From: [Brenda Larsen](#)
To: [Jeff Watson](#)
Subject: Nowak SP-10-00009
Date: Friday, July 30, 2010 4:29:21 PM

MEMORANDUM

SUBJECT: Nowak Short Plat SP-10-00009

RE: Nowak Short Plat SP-10-00009

*NOWAK*  
**ALEXANDER SHORT PLAT**  
WITHIN THE SW 1/4 SECTION 3 T18N R18EW  
KITITAS COUNTY WA.

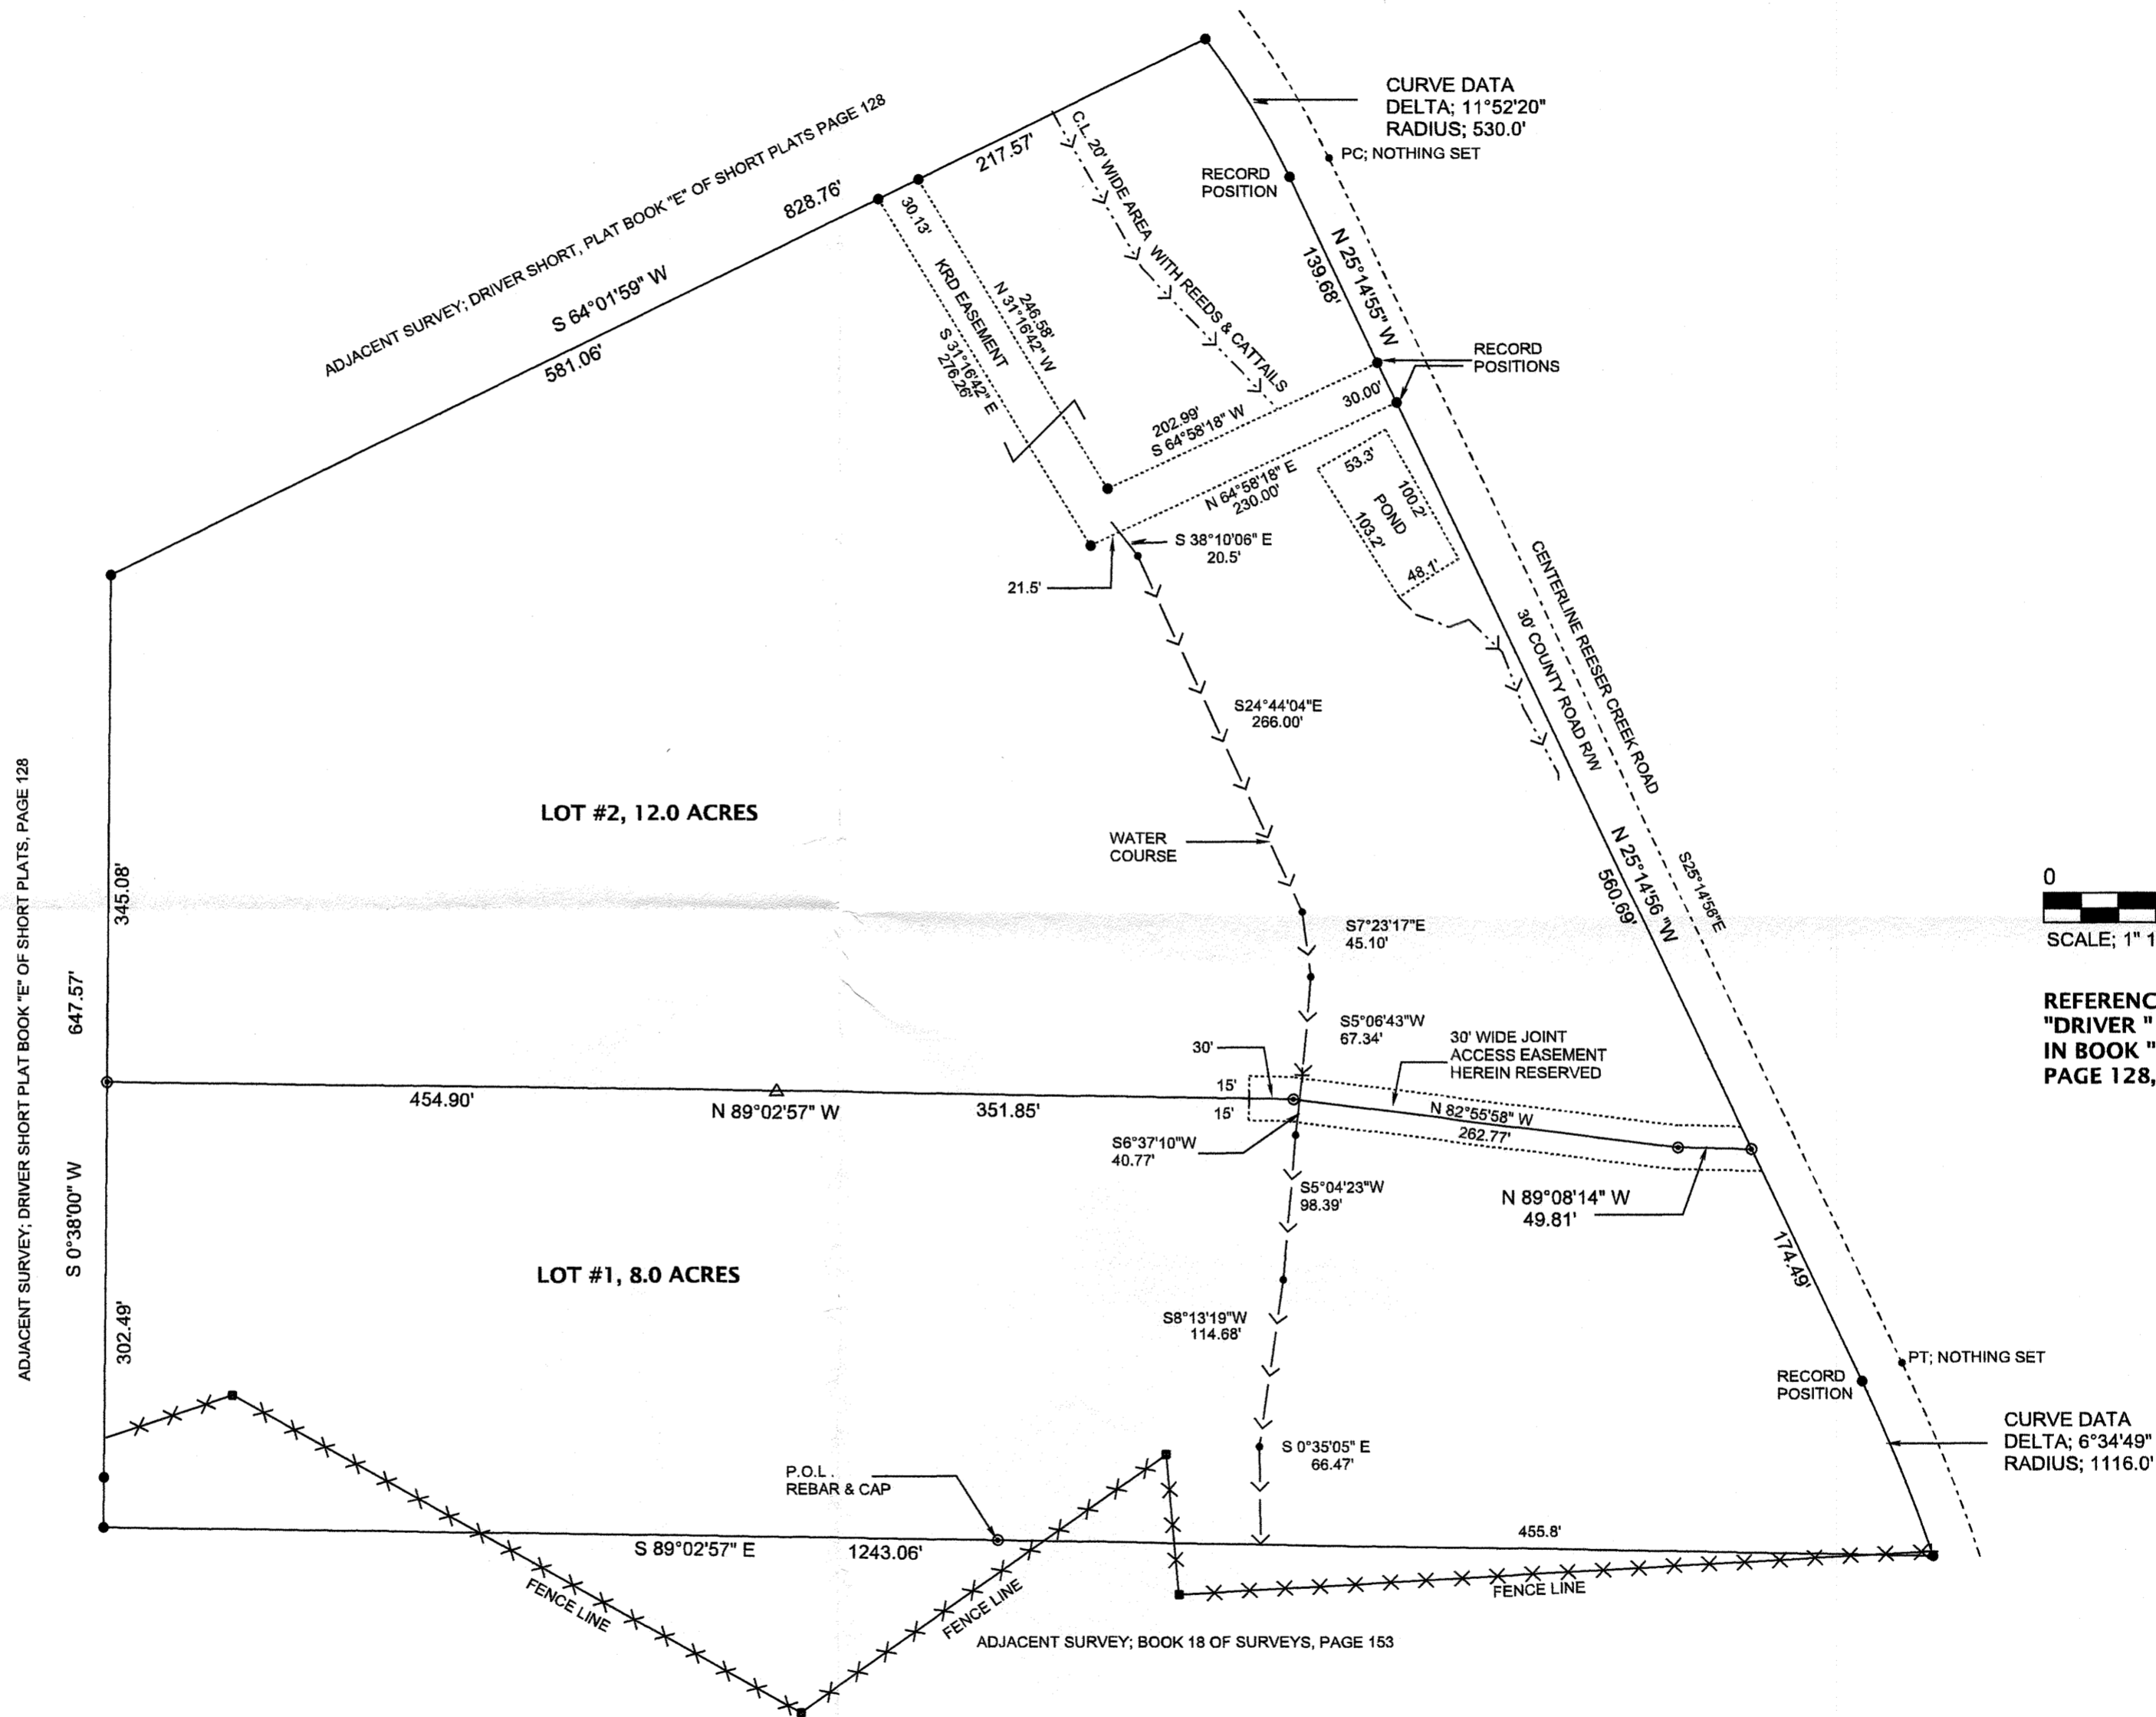
1. County Road Approaches: The access permit for the approach at 8621 Reecer Creek Road has expired (2007-0226). A new access permit application must be submitted in order to allow continued use of the approach. The new approach near the northeast corner is unpermitted and illegal, and an access permit application shall also be submitted for this approach. Current standards will be applied to both permits, which may require improvements to the approaches.

2. Joint-Use Driveway: A joint-use access shall serve no more than two tax parcels. See Kittitas County Road Standards, 9/6/05 edition.
 - a. Access easements shall be a minimum of 20' wide. The roadway width shall have a minimum width of 12'.

- b. The surface requirement is for a minimum gravel surface depth of 6".
 - c. Maintenance of driveway approaches shall be the responsibility of the owner whose property they serve. The County will not maintain accesses.

- d. Any further subdivision or lots to be served by proposed access may result in further access requirements.
3. Plat Notes: Plat notes shall reflect the following:

- a. Maintenance of the access is the responsibility of the property owners who benefit from its use.
 - b. An approved access permit will be required from the Department of Public Works prior to creating any new driveway access or performing work within the county road right of way.

- c. Any further subdivision or lots to be served by proposed access may result in further access requirements. See Kittitas County Road Standards.

- d. A public utility easement 10 feet in width is reserved along all lot lines. The 10 foot easement shall abut the exterior plat boundary and shall be divided 5 feet on each side of interior lot lines. Said easement shall also be used for irrigation.
4. Plat Approvals: All plats must show the acceptance signature of the County Engineer. The acceptance block shall be as follows (per KCC 16.24.170):

“The approval of this division of land includes no guarantee that there is a legal right to withdraw groundwater within the land division. The approval of this division of land provides no guarantee that use of water under the ground water exemption (RCW 90.44.050) for this plat or any portion thereof will not be subject to curtailment by the Department of Ecology or a court of law. “
